EXHIBITION OF STATE SIGNIFICANT DEVELOPMENT APPLICATION

CORRIMAL COKE WORKS - STAGE 2A - BUILT FORM

Development	State Significant Development - Corrimal Coke Works - Stage 2A - Built Form - Request to Provide Advice on the Environmental Impact Statement (EIS) (SSD-83789711)
Location	Lot 101 DP 1301632 Lot 4 DP 1313981 Lot 3 DP 1313981 Lots 3 and 4 DP 1313981, Lot 101 DP 1301632 Railway Street, CORRIMAL NSW 2518

B2.3 DRIVEWAY PLAN

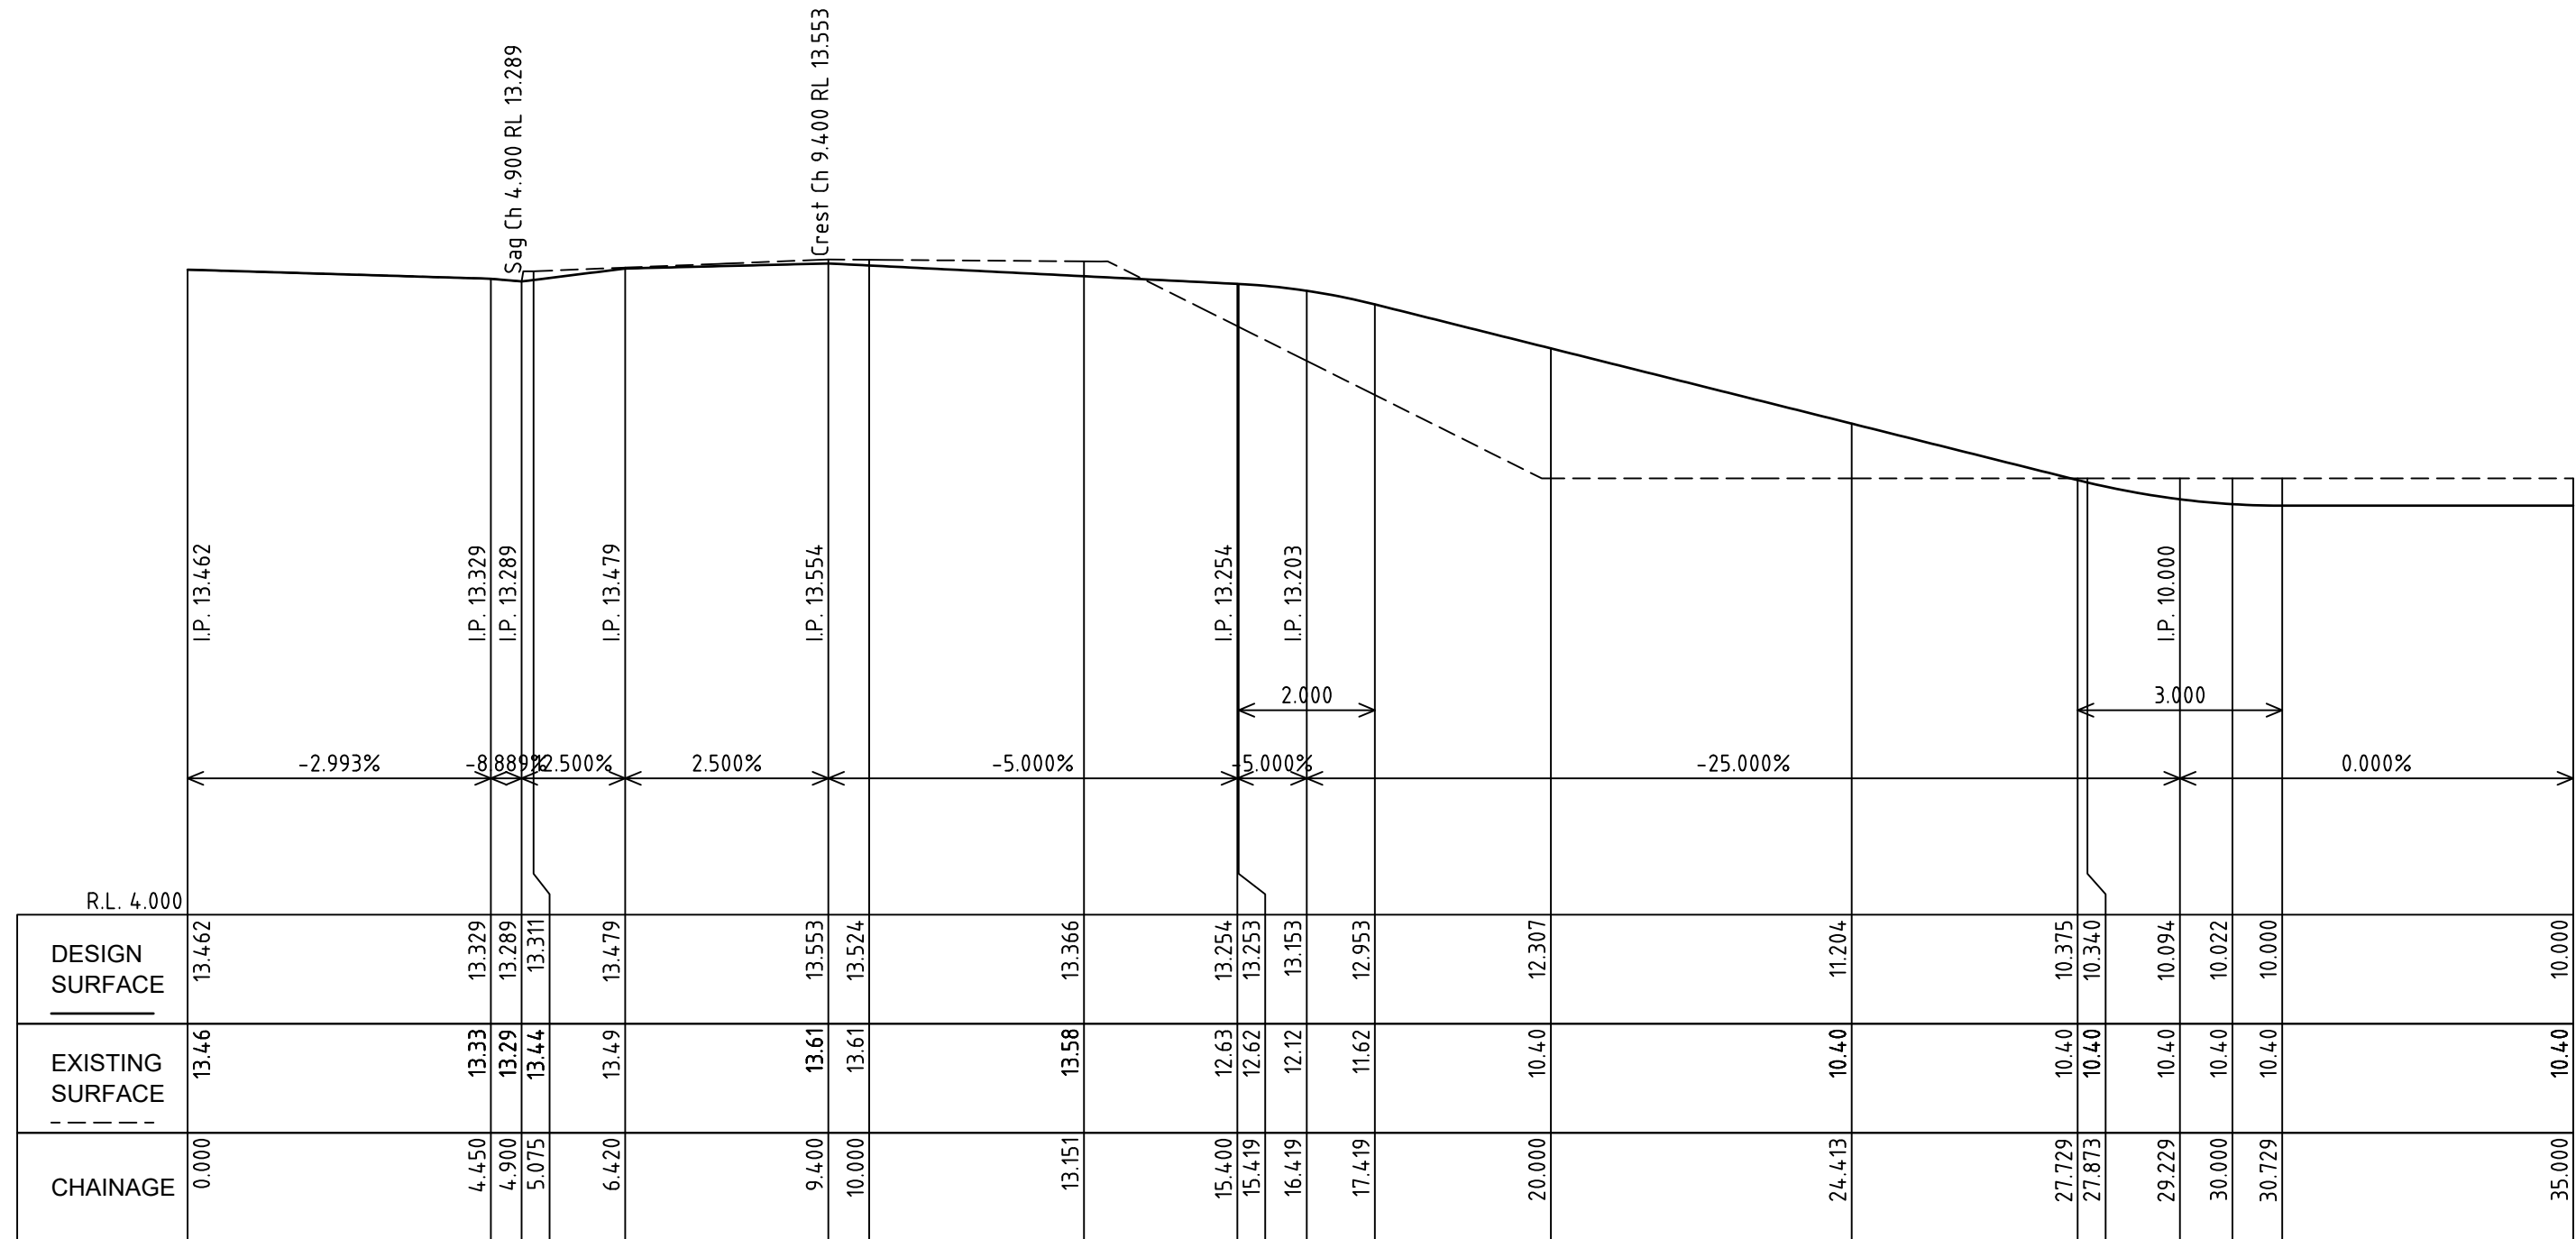
- Whilst Council is pleased to see that waste management will be managed within the sites of Buildings 2.2 and 2.3, it is noted that waste and other service vehicles utilising the loading zone will not be able to manoeuvre on site – thus necessitating a reverse manoeuvre either into or out of the site. The Department should consider potential impacts arising from this arrangement on vehicular, pedestrian and cyclist safety.

Building 2.1 GL Plan

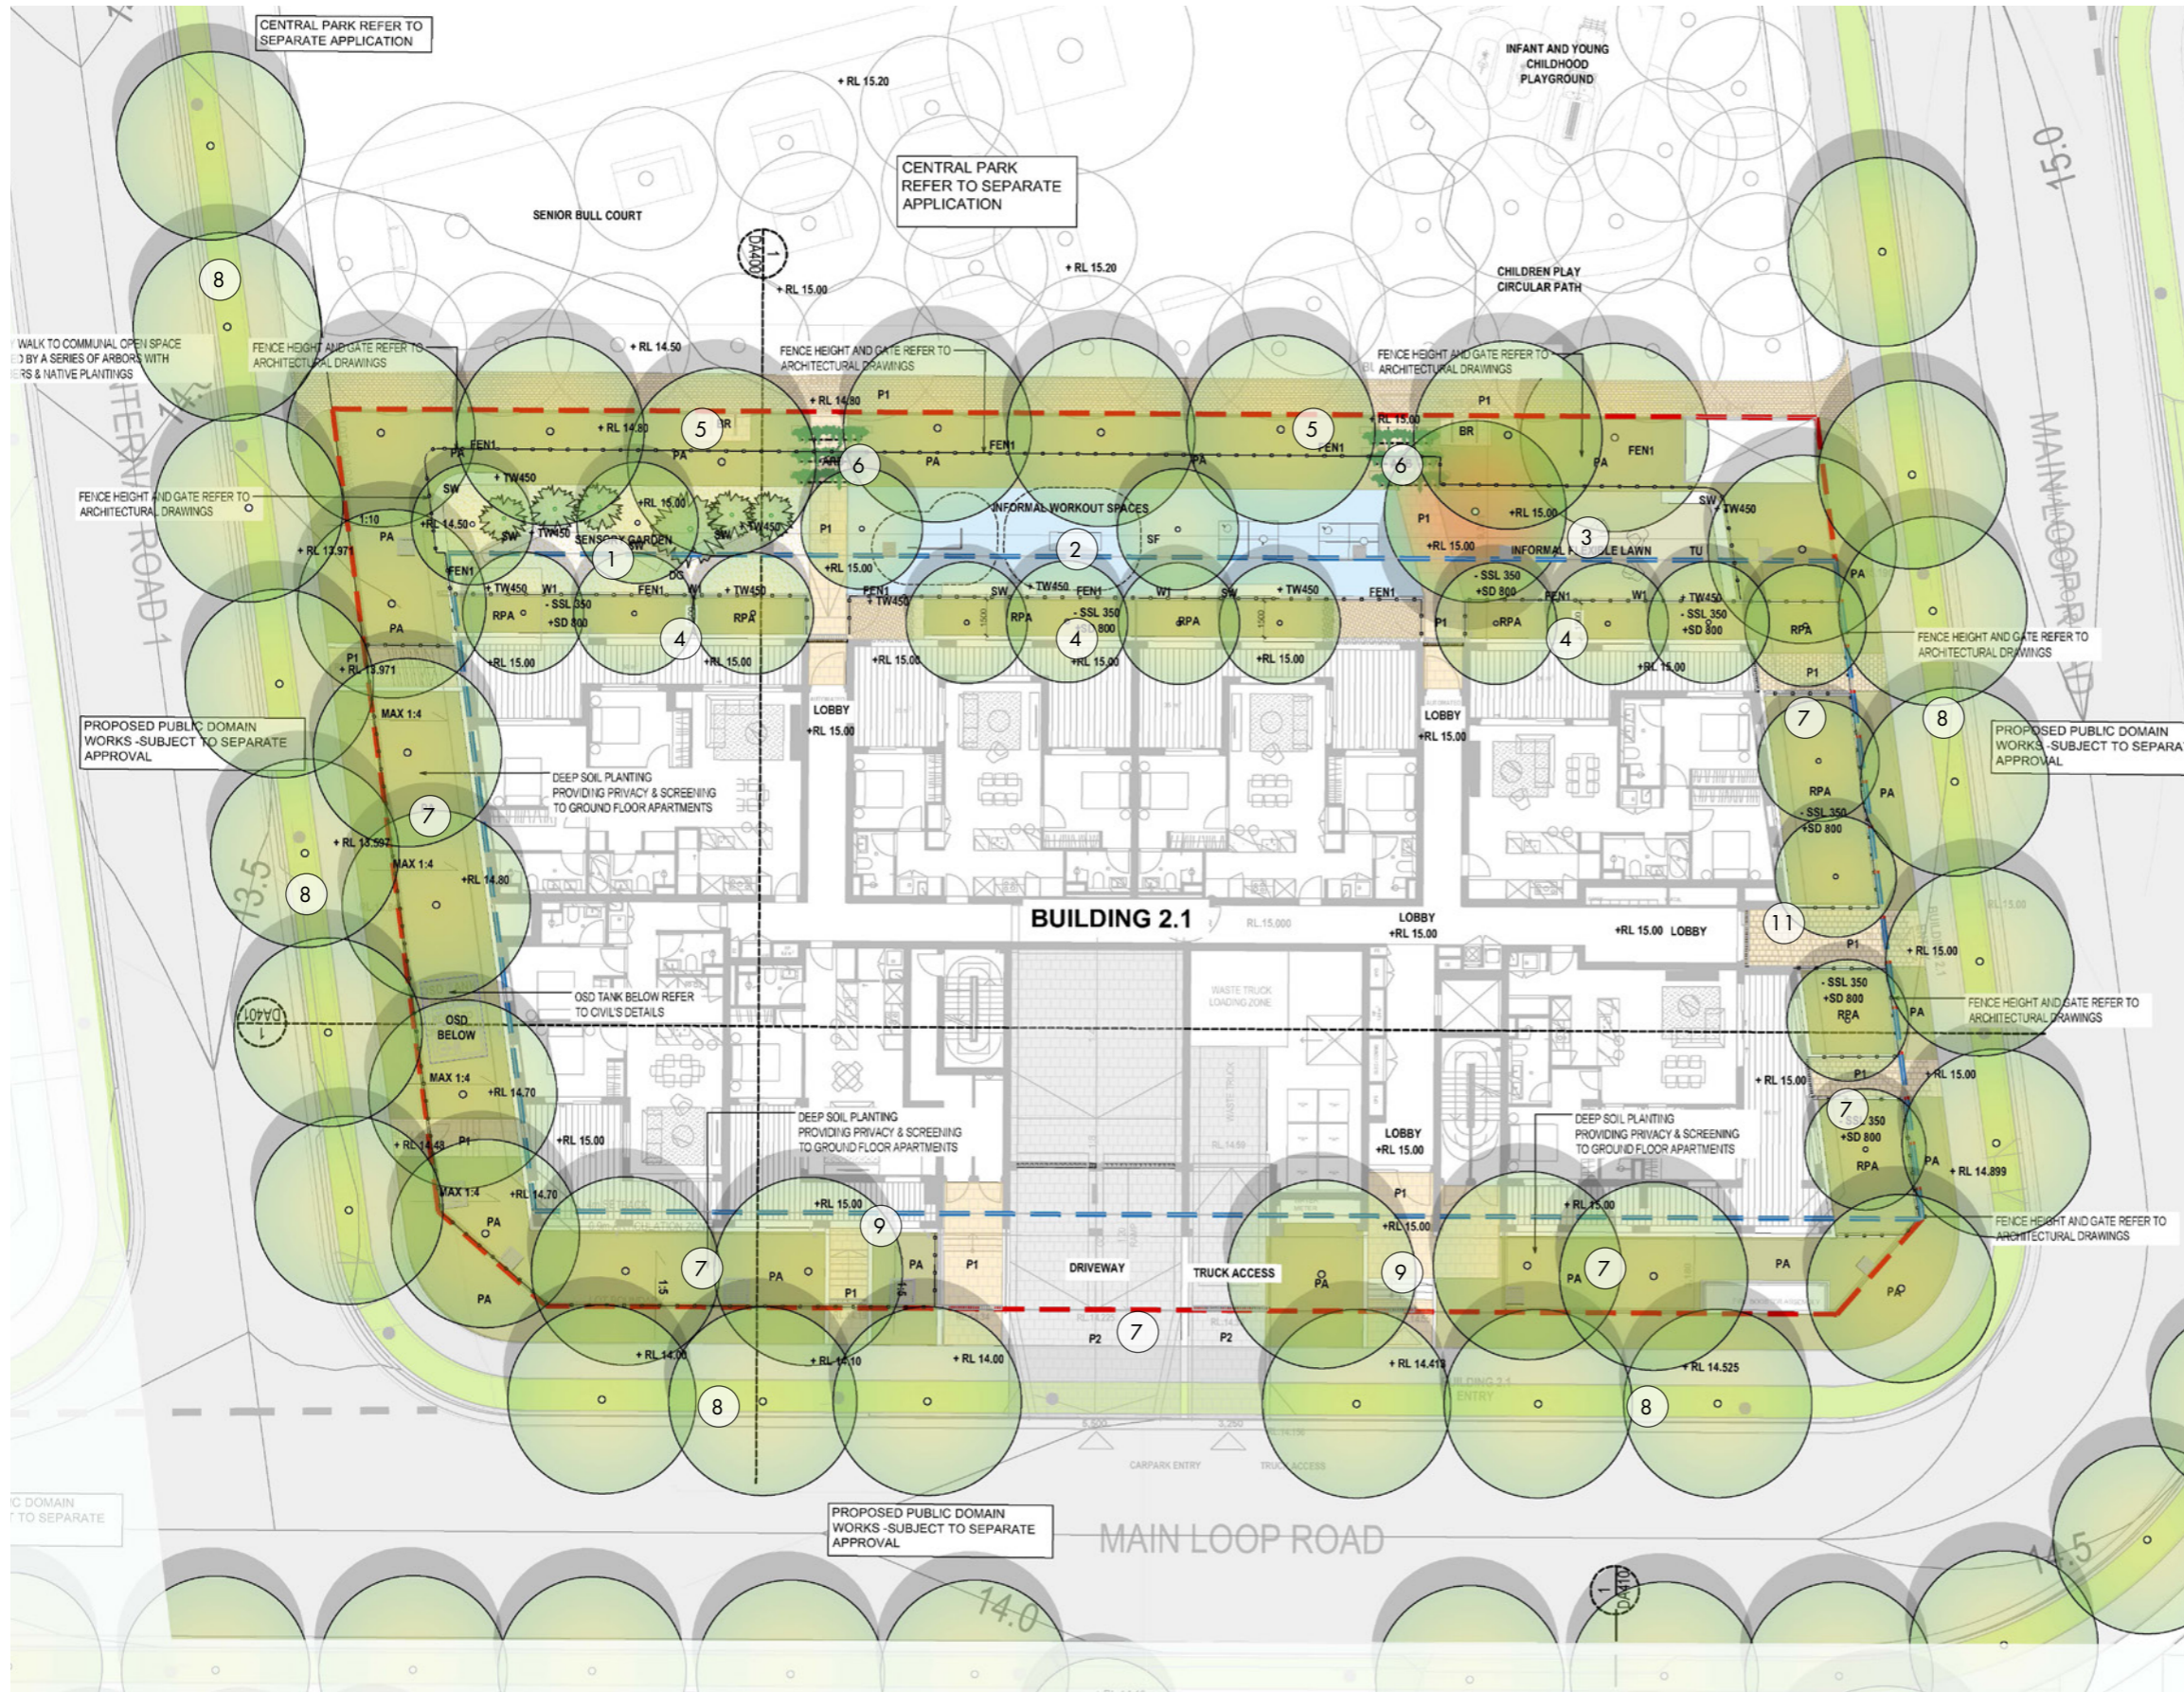
- The arbour structures provided at the gated entrance between ground floor COS and adjacent central park is supported as it improves wayfinding.
- The inclusion of informal workout spaces on the Ground floor COS directly adjacent to POS areas is questioned given the proximity to one another and potential for amenity of POS areas to be compromised. More quiet /passive functions may be more appropriate in this location.
- Level 3 northern rooftop COS has no clear function and is presented as a circular pathway around an island planter. More meaningful program is recommended in this location that differs to the COS offering elsewhere.

BUILDING 2.3 & 2.4 Design

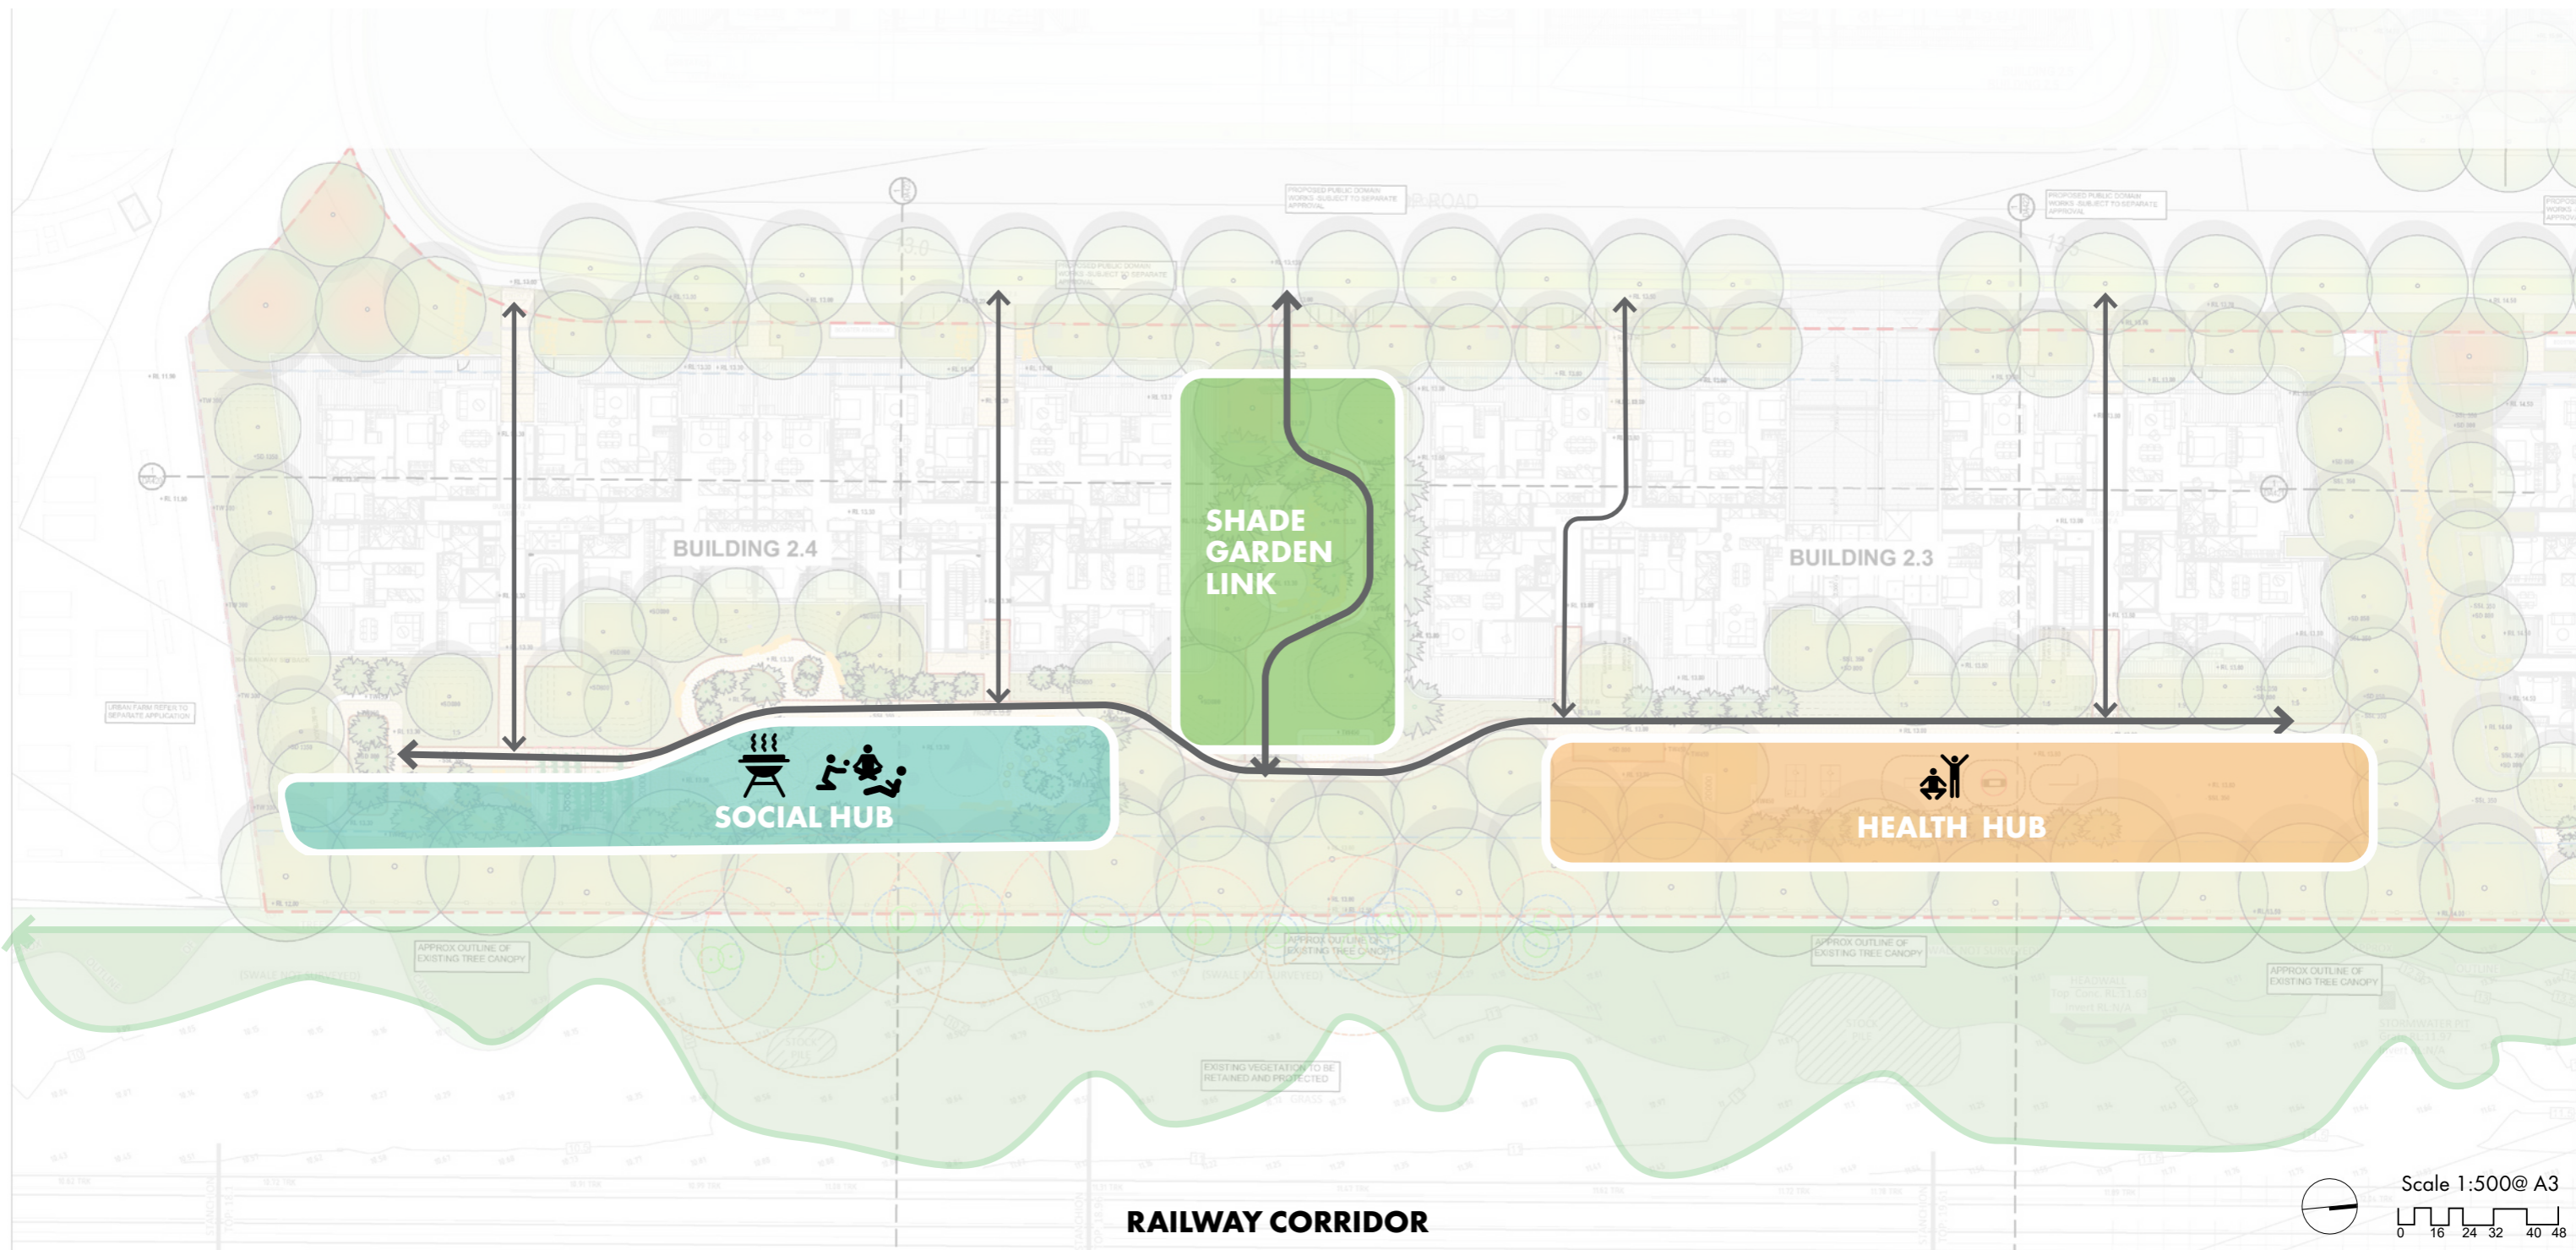
- The combination and distribution of COS offering at ground floor is commended and provides both buildings with good secure access to all facilities.
- The arbour structure proposed between the 2 buildings as an option for secure convenient access for residence is supported (improves pedestrian circulation and wayfinding).
